Our Ref: EN010148

Date: 23 September 2025

### **Application by RWE Renewables UK Solar and Storage Limited for an order granting development consent for the Tween Bridge Solar Farm project**

#### **Advice following issue of decision to accept the application for examination**

Figure 2.3: Heights Parameters Zonal Plan

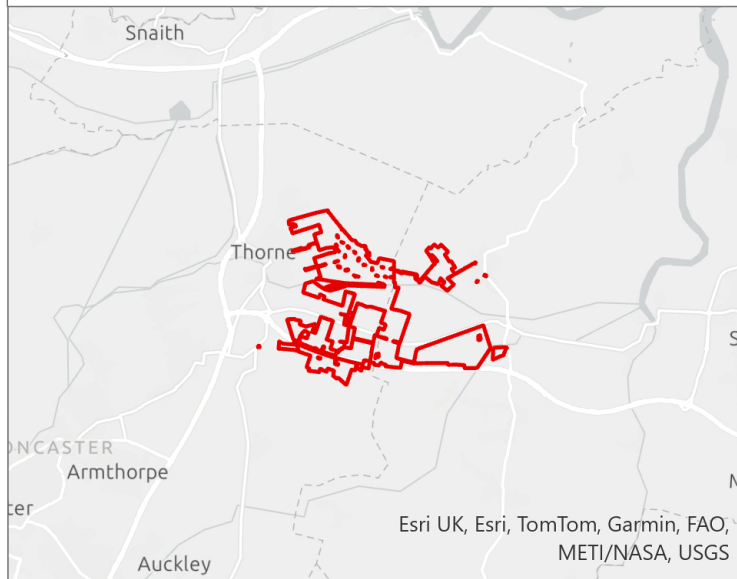
Whilst the maximum dimensions of the solar panels are expressed, the maximum height of the mounting structures is not. The document (page 5) states in part:

*'The mounting structures will be fixed to the ground by galvanized steel or other material poles which are **typically** driven into the ground to a maximum depth of 3m' (emphasis added)*

This needs to be addressed (tightened up). The implications for any requirement for raising panels above flood levels should be fully taken into account and assessed in the relevant ES chapters.

It would be beneficial if the applicant could produce a colour coded plan showing maximum panel, solar station, substation and BESS heights across the order limits based on 1 in 1000 flood levels. It is noted that FRA Appendices F and G include data for 1 in 1000 flood levels (+ 100mm freeboard). However, the applicant should provide a similar plan for each component (solar, BESS etc) of the development showing maximum heights. The applicant should consider linking this plan to the Design Parameters Document and should ensure that these maximum heights are reflected in the worst-case scenario assessment for each respective ES topic.
